Town & Country Planning Act 1990 (as amended)
Town and Country Planning (Development Management Procedure) (England) Order 2015
Application for Planning Permission

Development Erection of 1 No. two-bedroomed detached bungalow. This application is a Departure from the Development Plan.

Location land adjacent to Pindars Lyminster Road Lyminster

DRAWING PROPOSED SITE PLAN DATE: JANUARY 2018 DRAWN: T. Murray	SCALE 1/500
DRAWING: 18/04/4	REVISION:

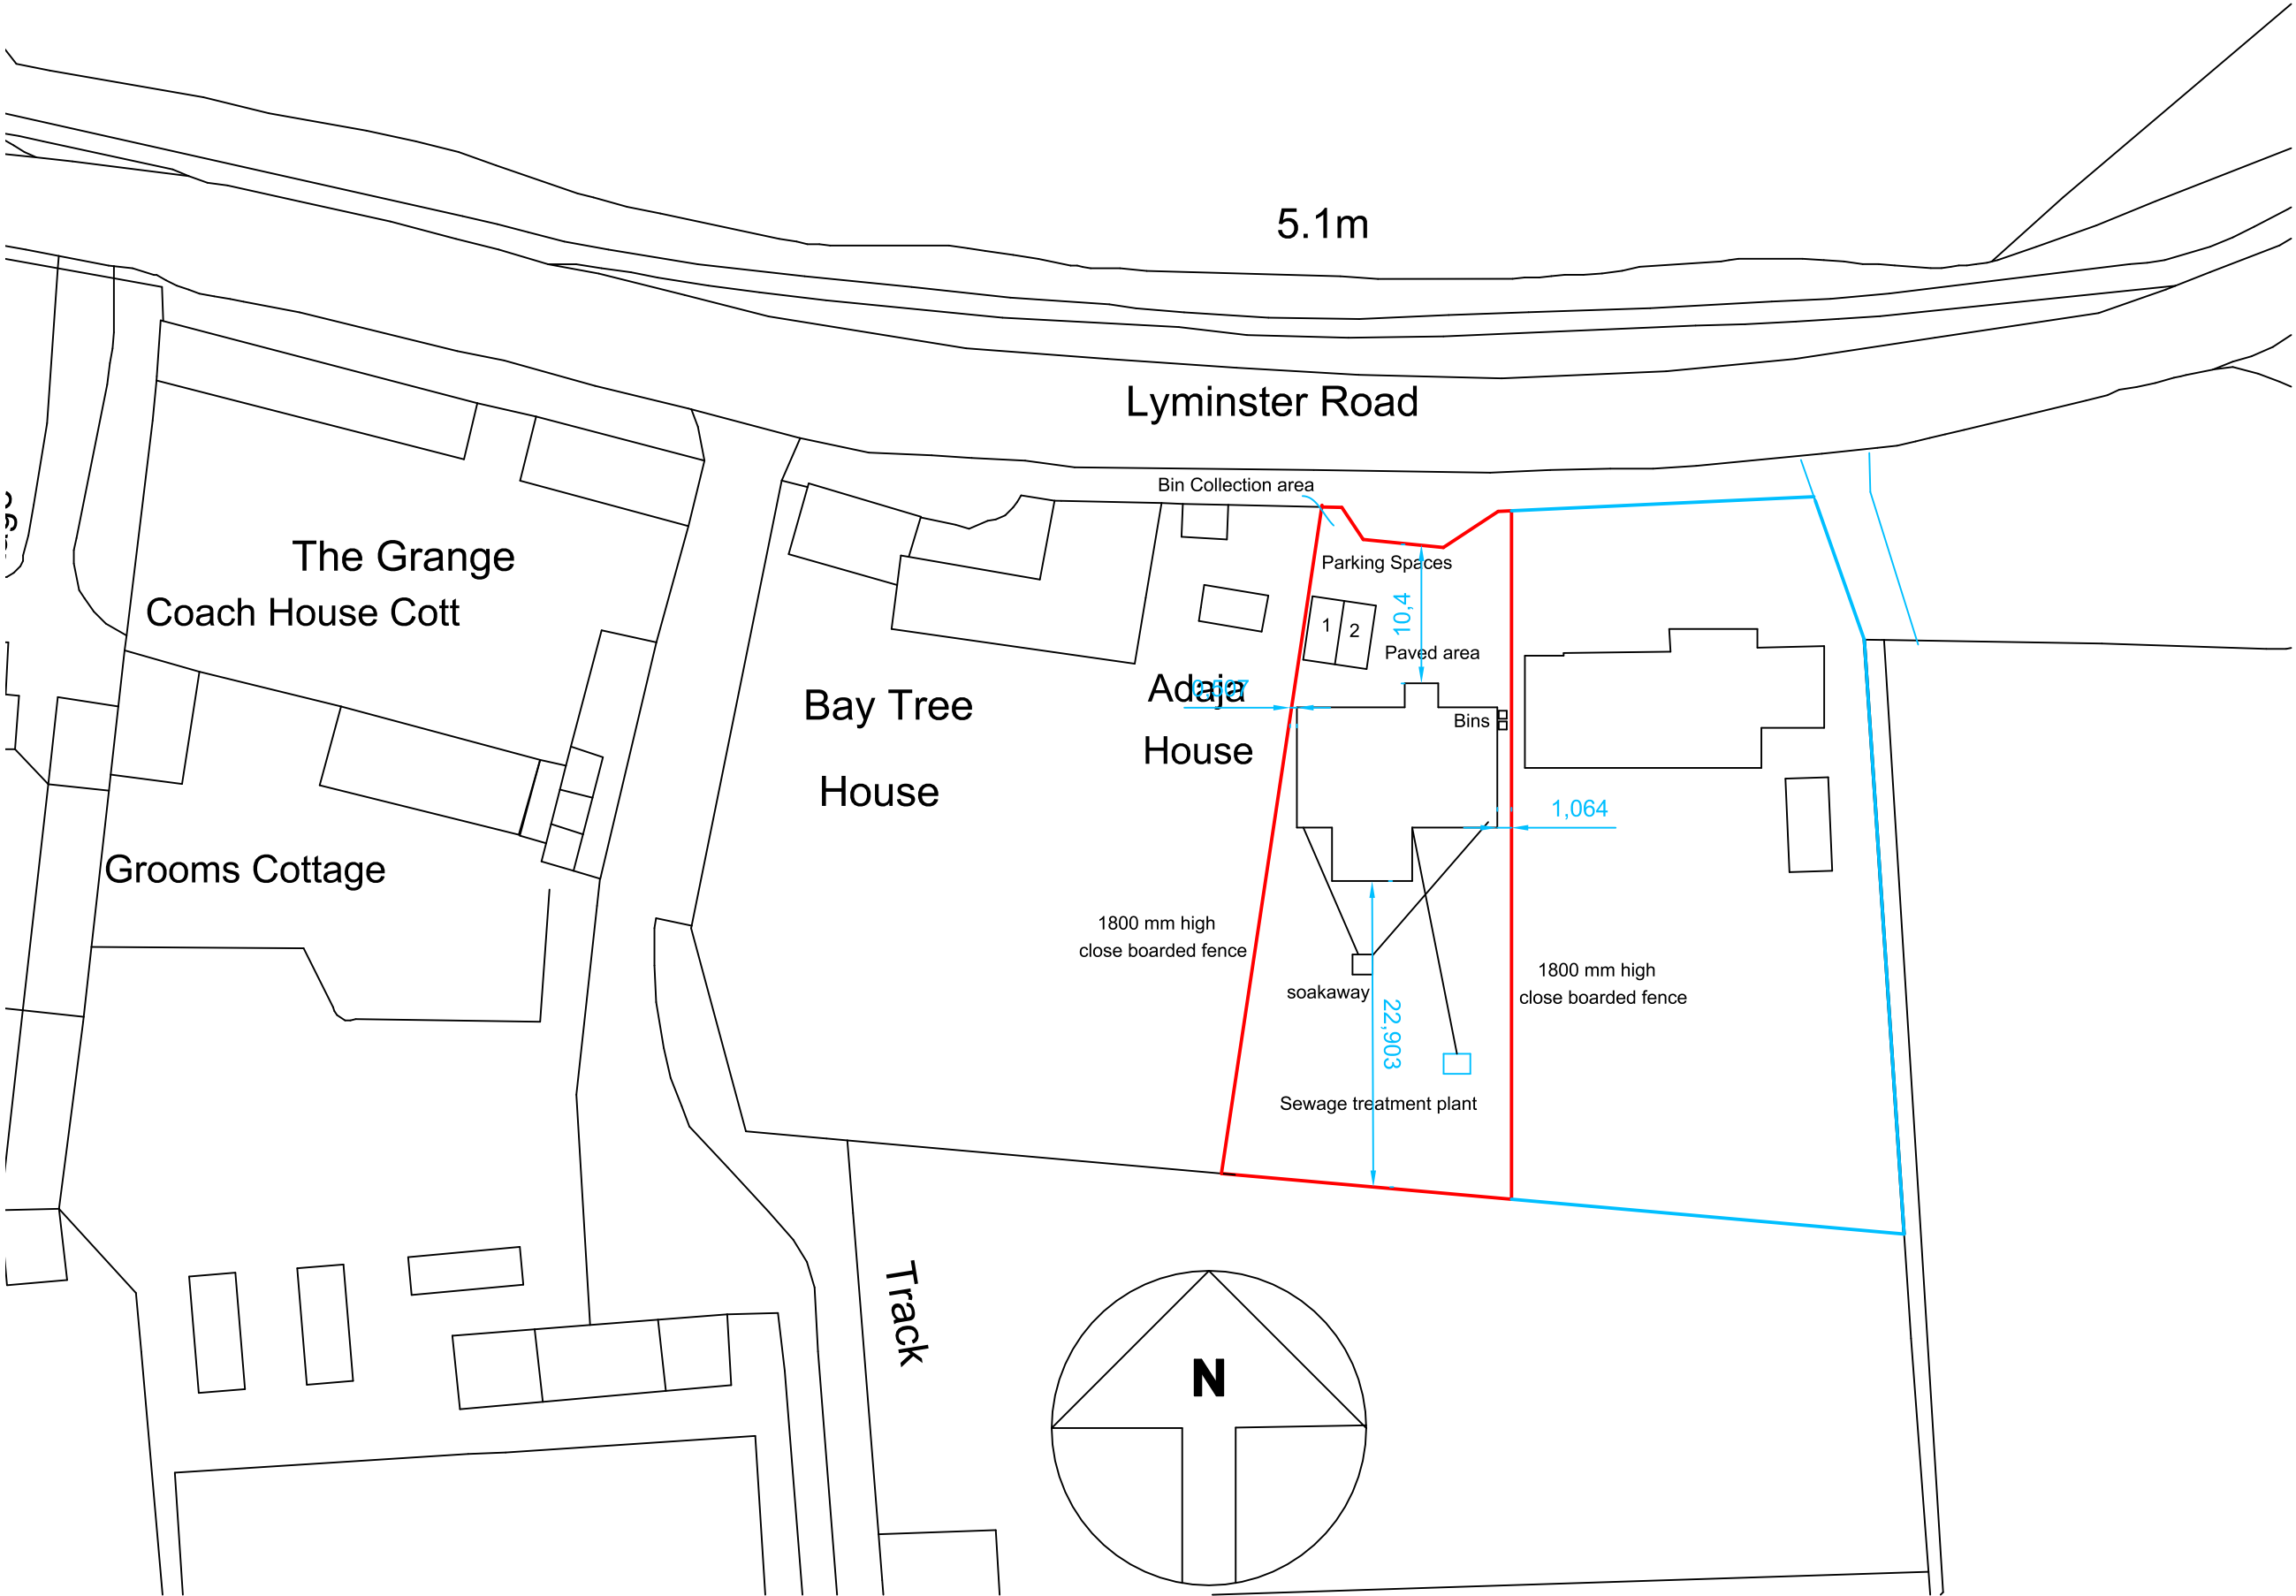
Block Plan Amend

Please submit 1 electronic or 3 paper copies of a block/site plan at a scale of 1:500 or 1:200. Further details of what must be included on the plan can be found in the National Validation Requirements. Please provide measurements from the proposal to the site boundaries and show the position of the bins.
